Planning Inspectorate

Application by Springwell Energyfarm Limited for an Order Granting Development Consent for the Springwell Solar Farm

Issue Specific Hearing 3

Action Points:

OS Open data / © Natural England / © DEFRA / © DECC / © English Heritage. Aerial Photography - ESRI, DigitalGlobe, GEOEye, i-cubed, USDA FSA,USGD, AEX, Getmapping, Aerogrid, IGN,IGP,swisstopo, the GIS User Community

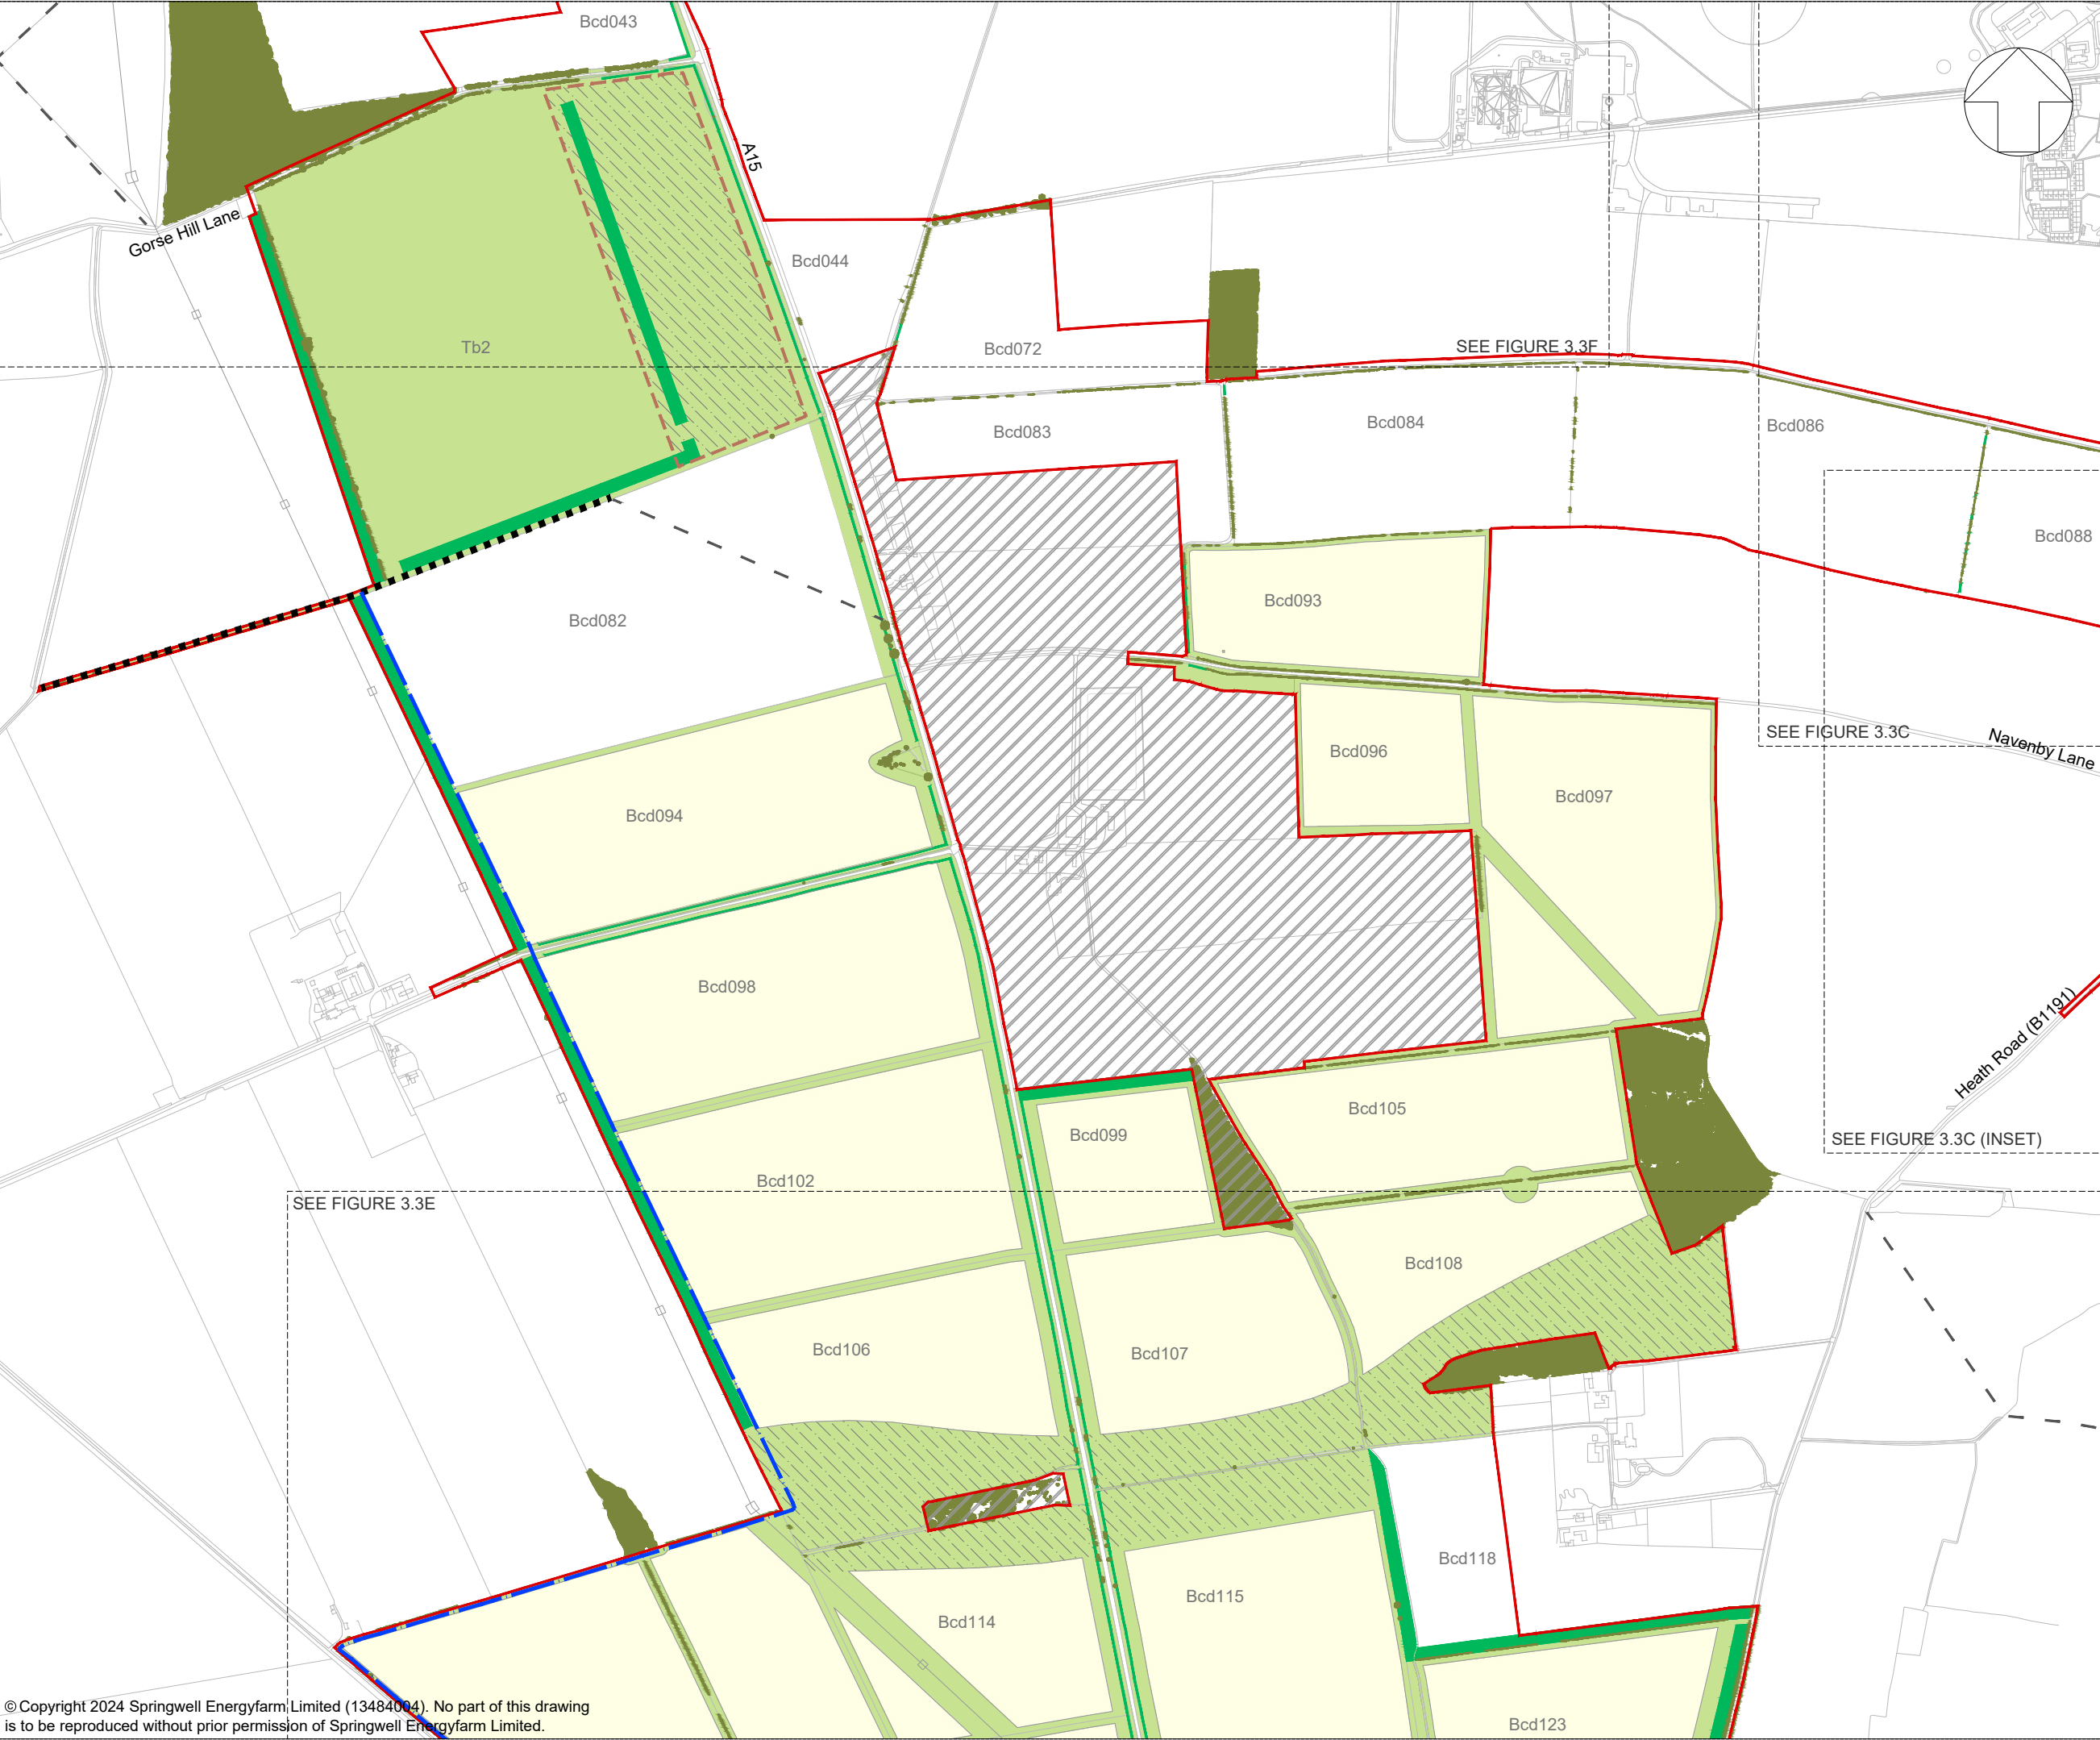
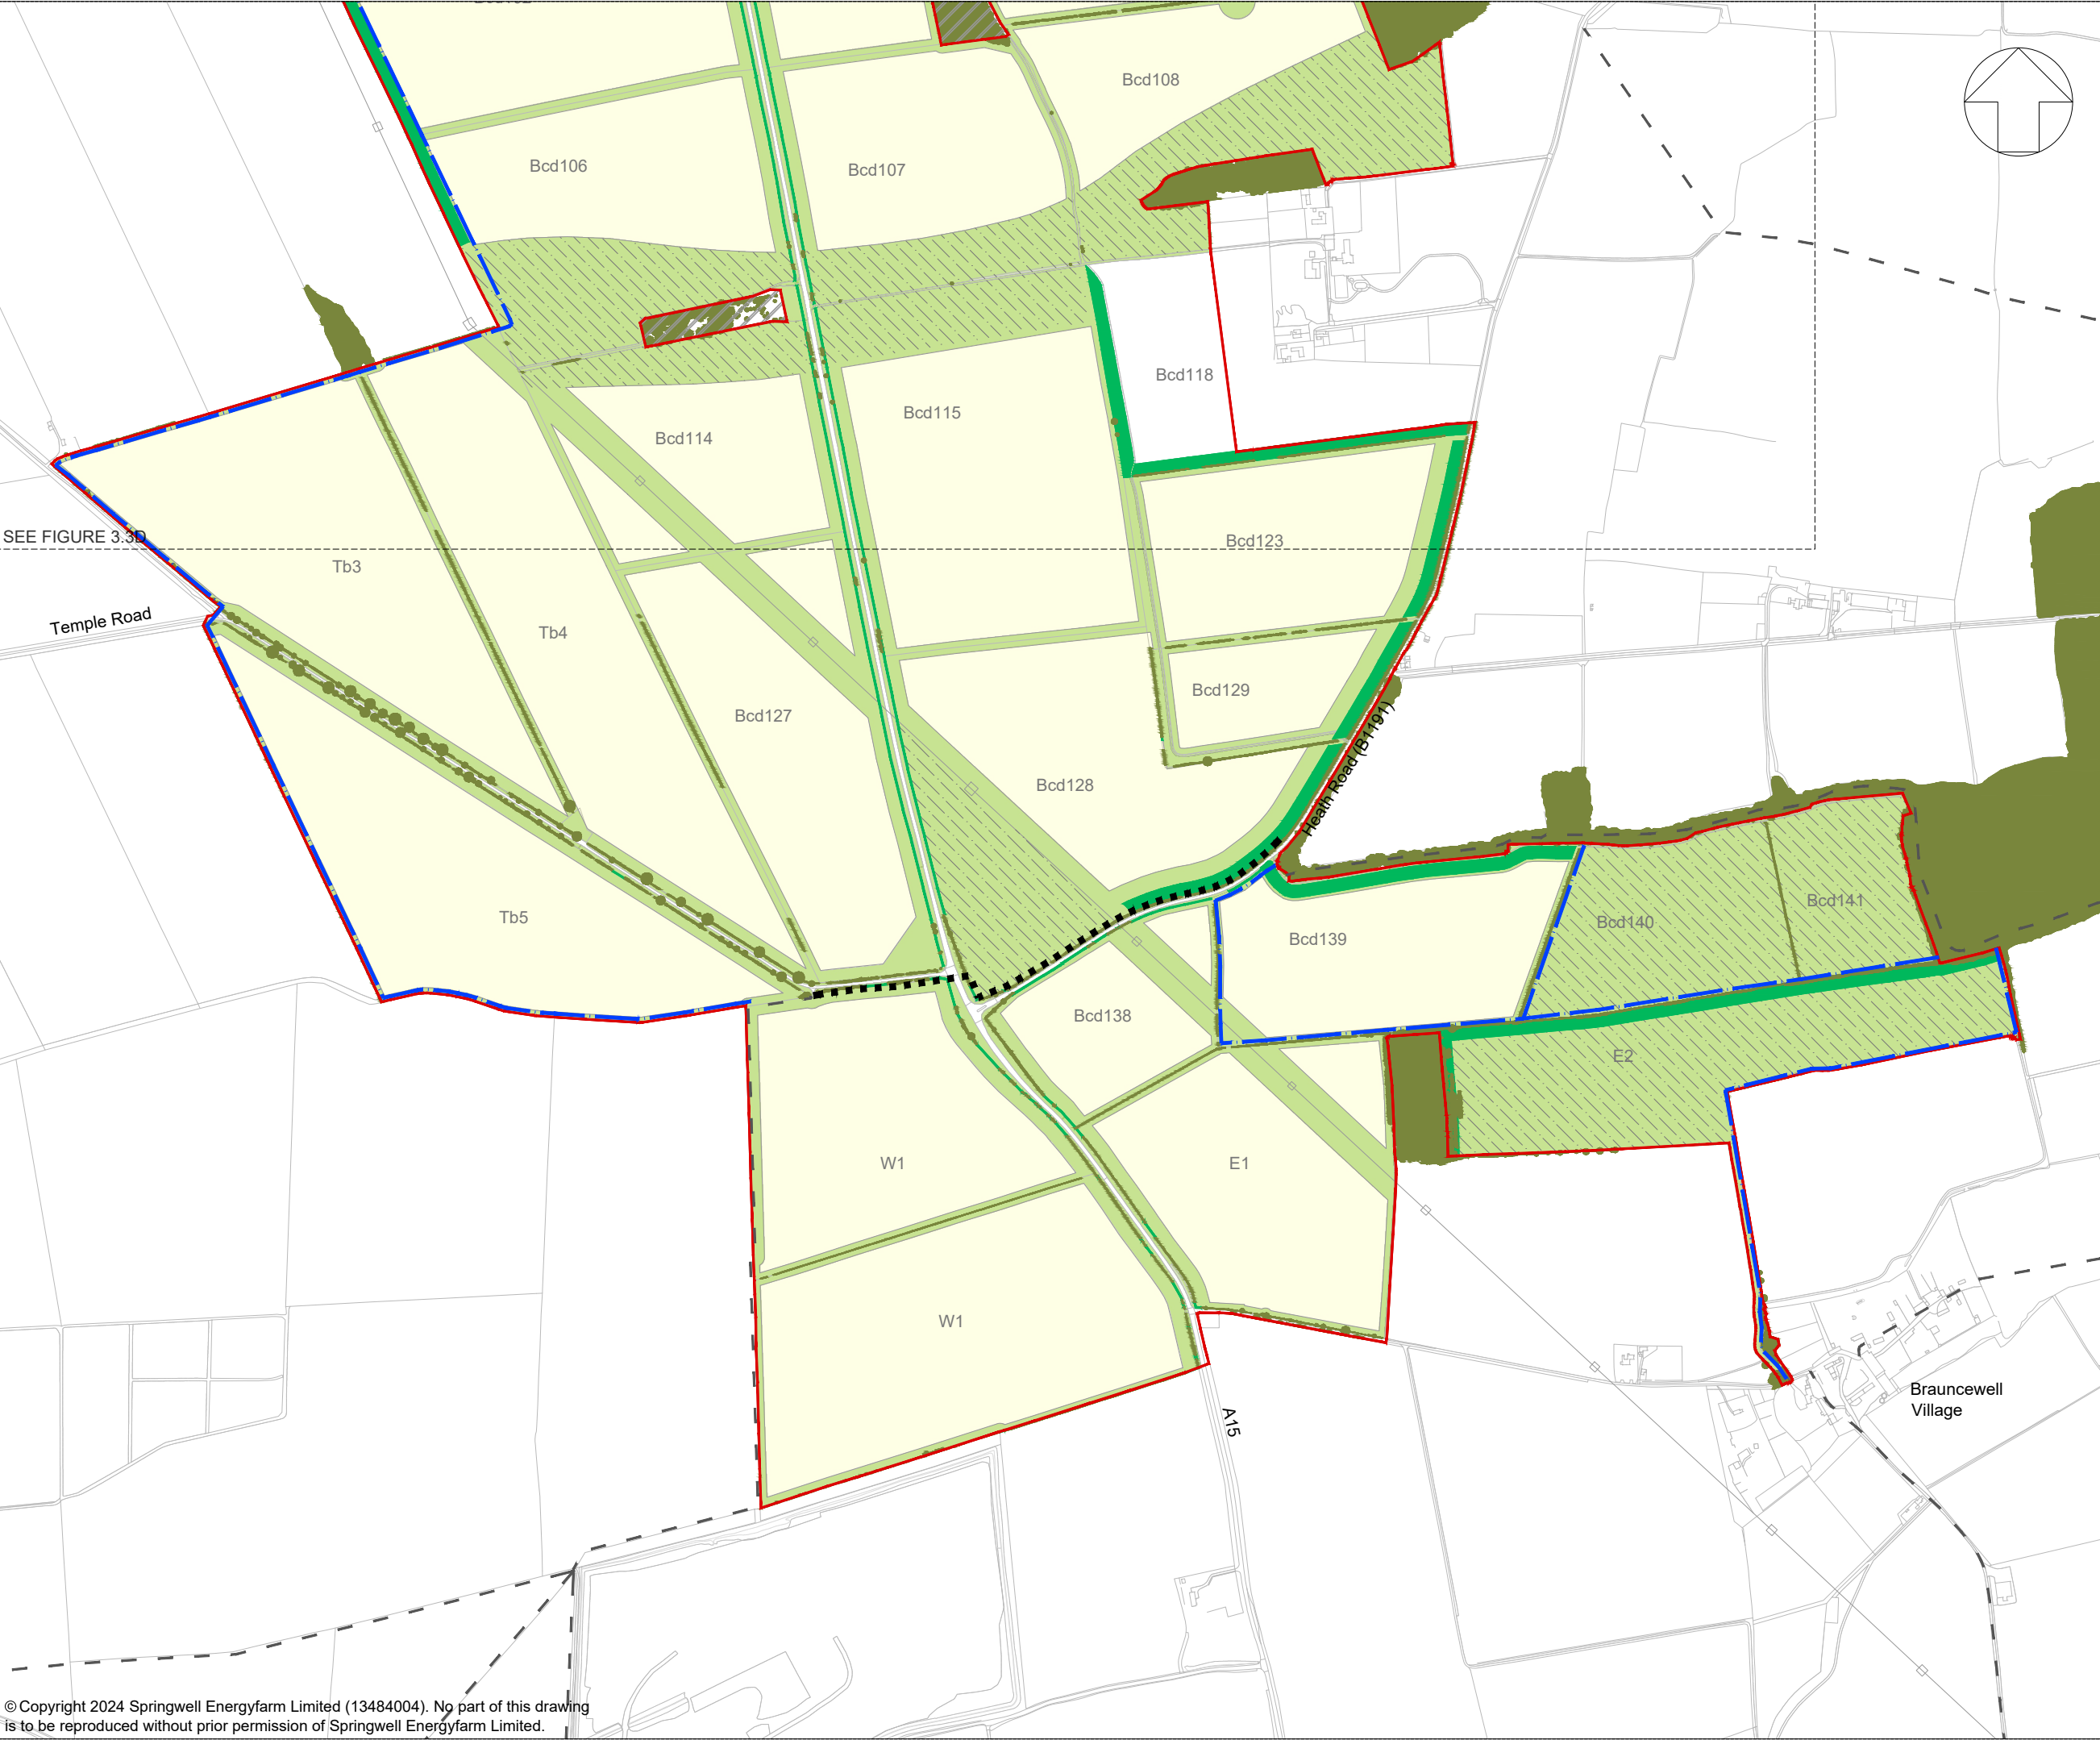
No.	Party	Action	Deadline
		'sealed over' land has been considered as a permanent impact.	
10	Applicant / EA	To have further discussions on wording relating to unexpected contamination	D3
11	Applicant	Scarce Arable Flora - Confirm whether the green infrastructure margins in field Bcd115 shown on the green infrastructure BNG parameters should extend to the north-east corner of the field to include target note location 9 and also whether the proposed strategic tree belt clashes with target note location 10.	D3
12	Applicant	Provide map showing location of proposed mitigation works for ground nesting birds.	D3
13	Applicant	Provide revised dDCO including anticipated BNG figures in Requirement 8.	D3
14	Applicant / NKDC	Further discussions to take place in relation to the data used to assess tourism effects and monitoring measures that could be put in place to understand the impact on tourism related to the use of PRow and stepping out network.	D3
